Department for Transport

Date: 13 August 2021

Application by North Somerset District Council (“the Applicant”) for an Order granting Development Consent to construct a new railway on the trackbed of the former branch line from Bristol to Portishead including associated works (“the Proposed Development”)

REQUEST FOR COMMENTS FROM THE APPLICANT AND BRISTOL PORT COMPANY (“BPC”)

Drawing Title
**PORTISHEAD STATION
3D VIEWS**

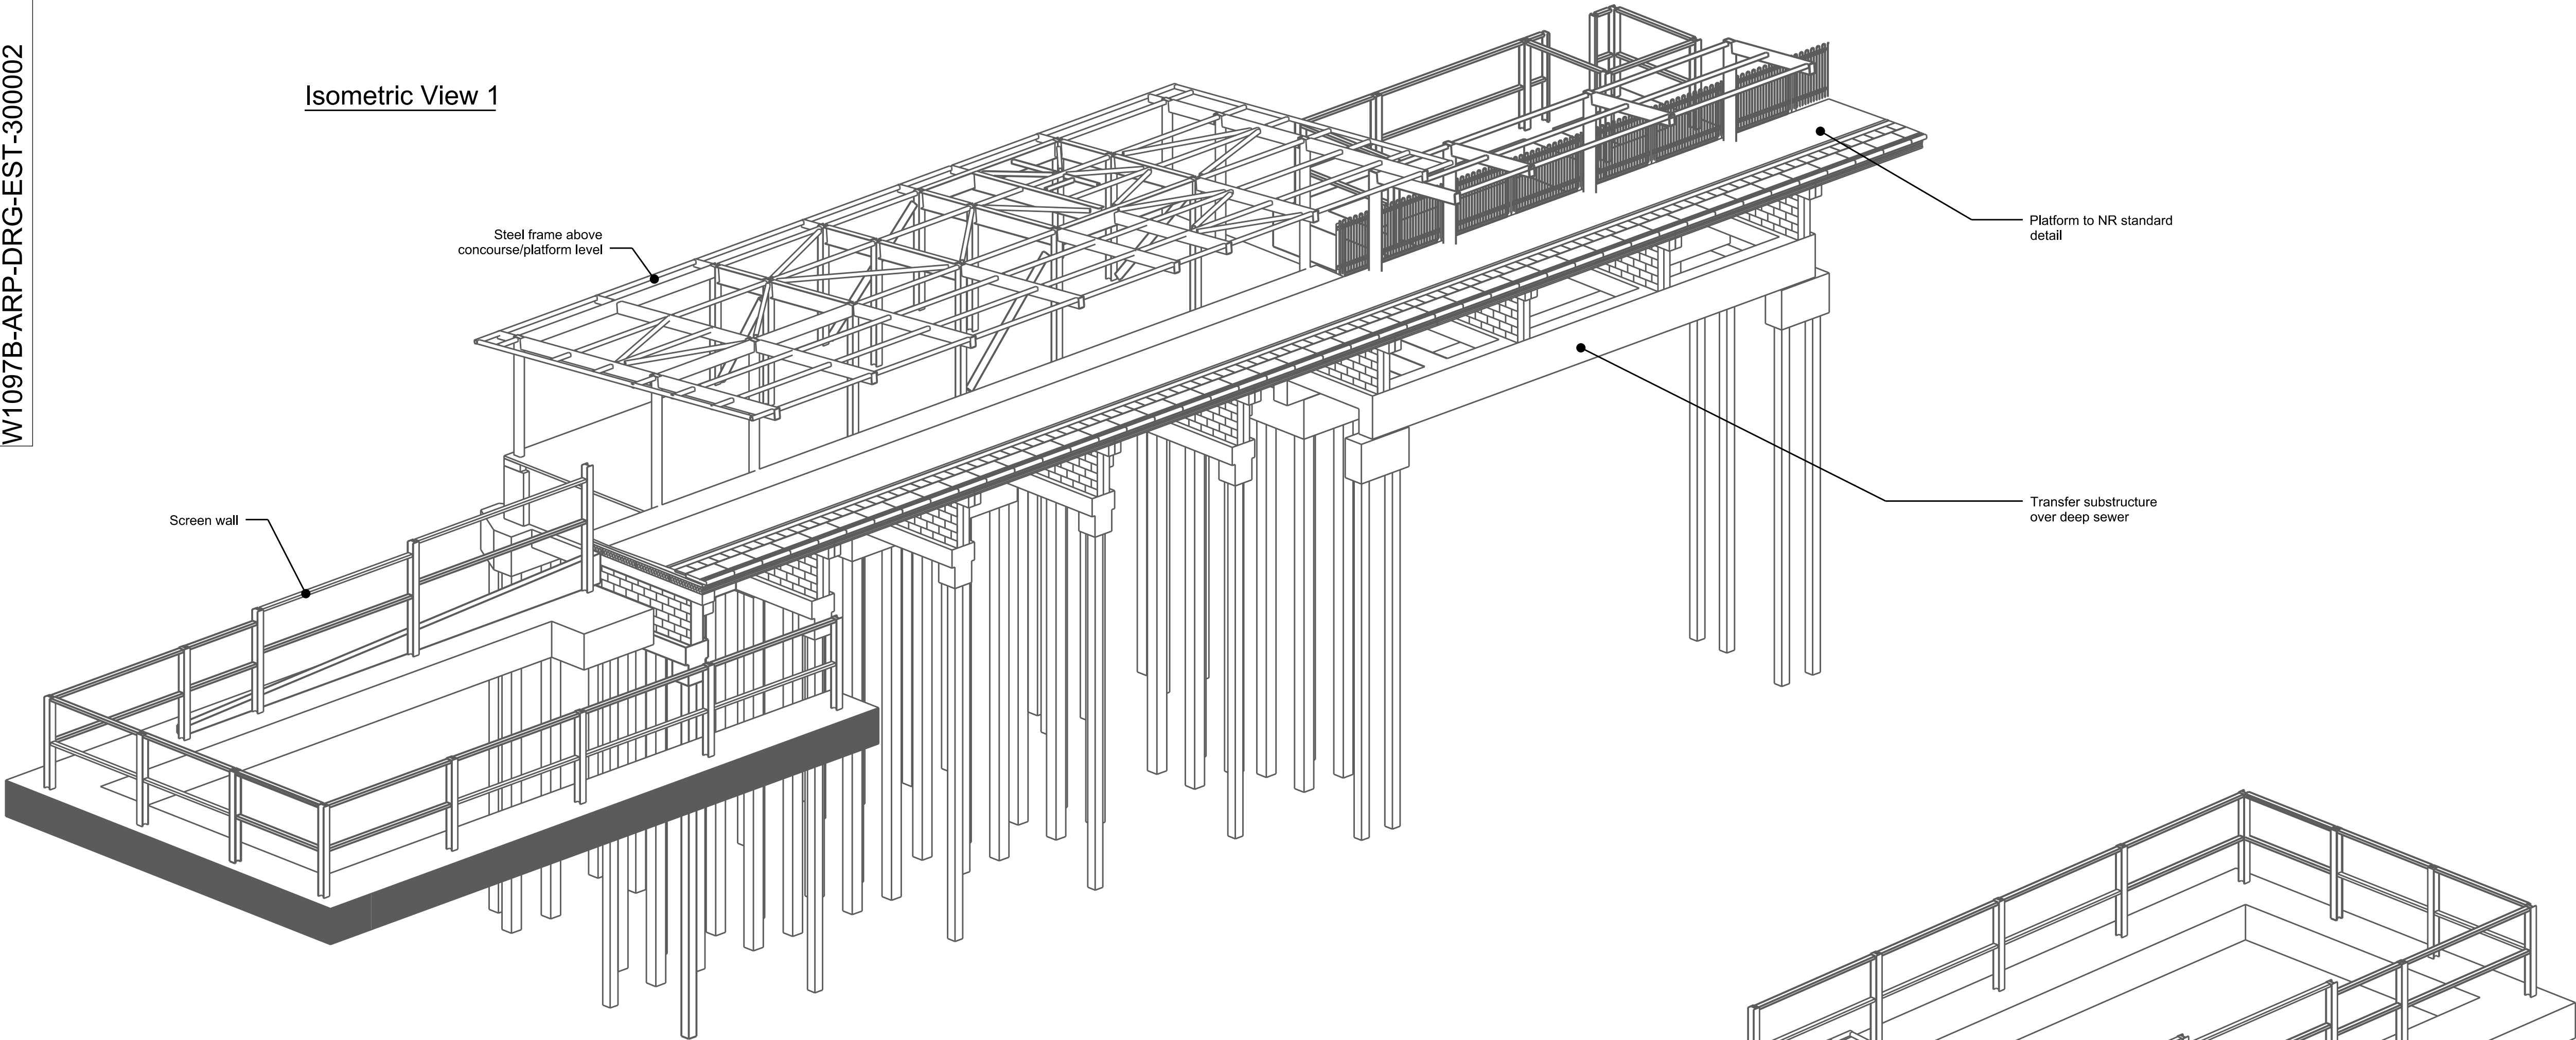
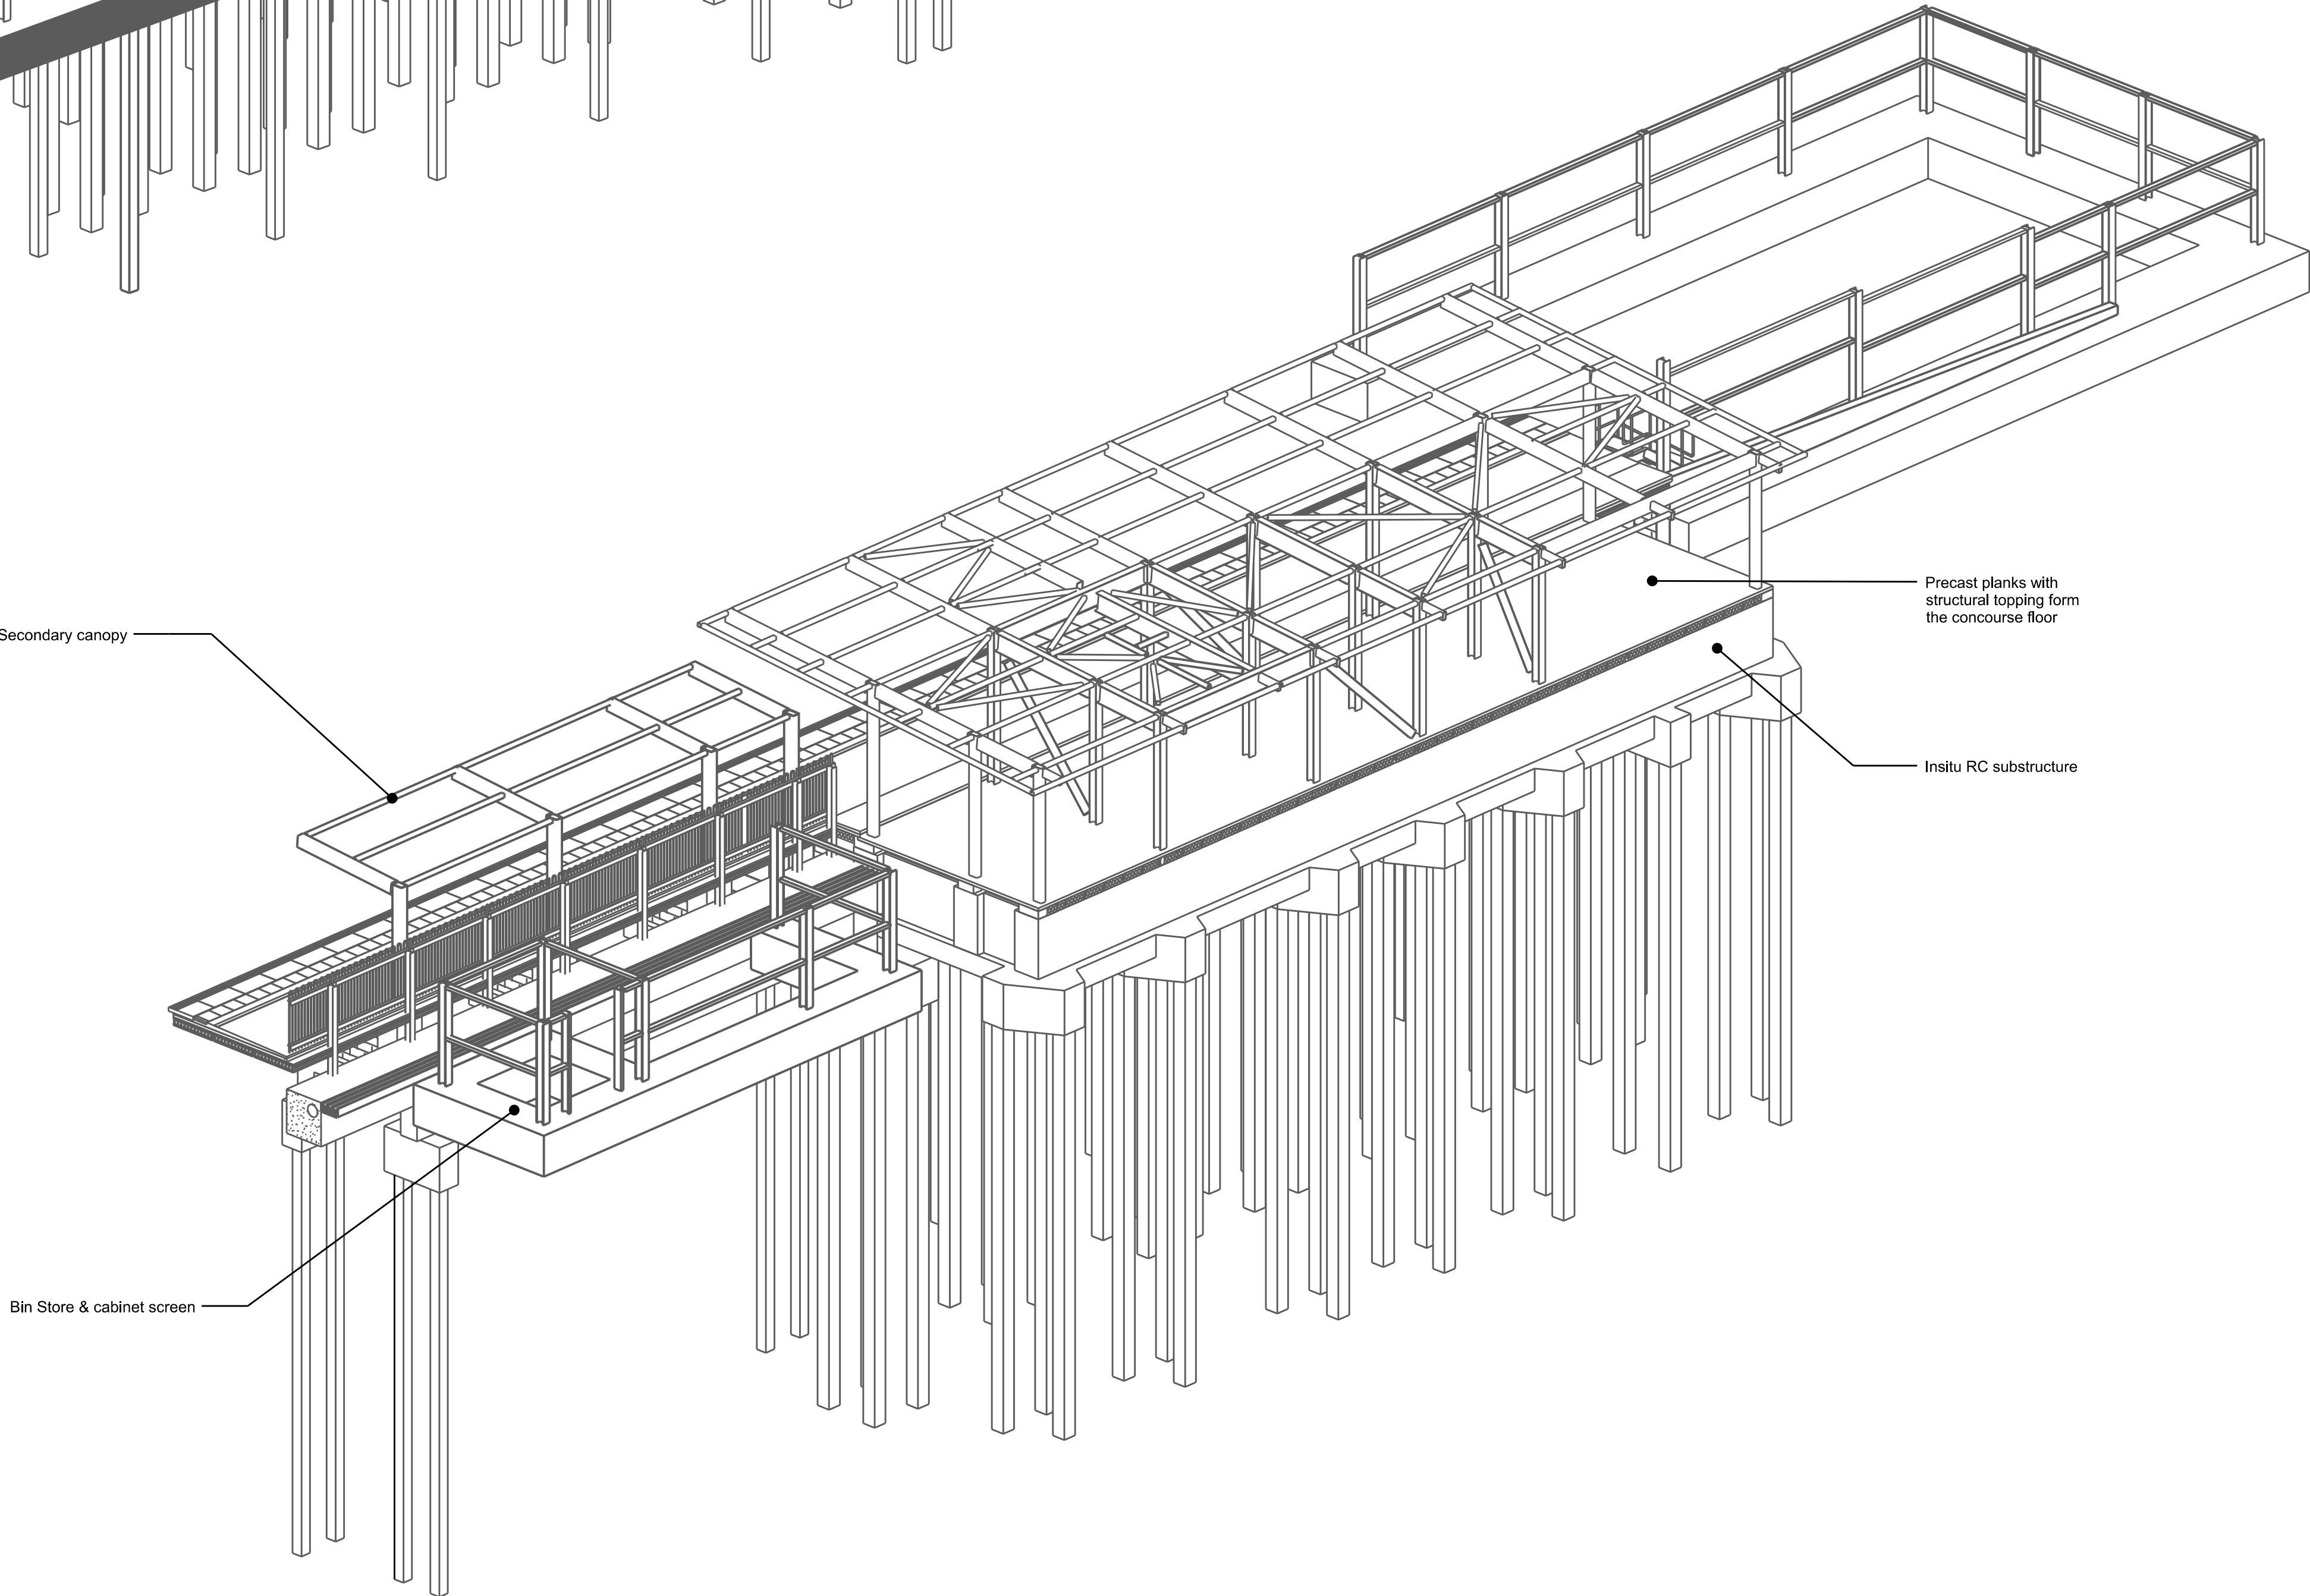
The Secretary of State notes the matters raised at the Examination regarding Trinity Footbridge and is minded to remove Trinity Footbridge from Work No 7 of the proposed order. As such, the relevant plans below would need to be updated.

- Works Plans [\[REP5-004\]](#) – 674946.BQ.42.01-301 Rev P and 674946.BQ.42.01-318 Rev P
- General Arrangement Plans [\[REP7-003\]](#) – 674946.BQ.42.01-571 Rev J
- Cross Section Plans [\[REP5-007\]](#) – 467470.BQ.04.20-SK300 Rev I and 467470.BQ.04.20-SK301 Rev I
- Portishead station layout and landscape plans [\[REP5-008\]](#) – 467470.BQ.04.20-102 Rev Y
- Portishead station plans [\[APP-018\]](#) – W1097B-ARP-DRG-EST-300001 Rev A02.
- The relevant design drawings listed in Requirement 4 (submission and approval of detail design)

The Applicant is asked to provide the Secretary of State with updated plans to reflect the removal of Trinity Footbridge from Work Number 7.
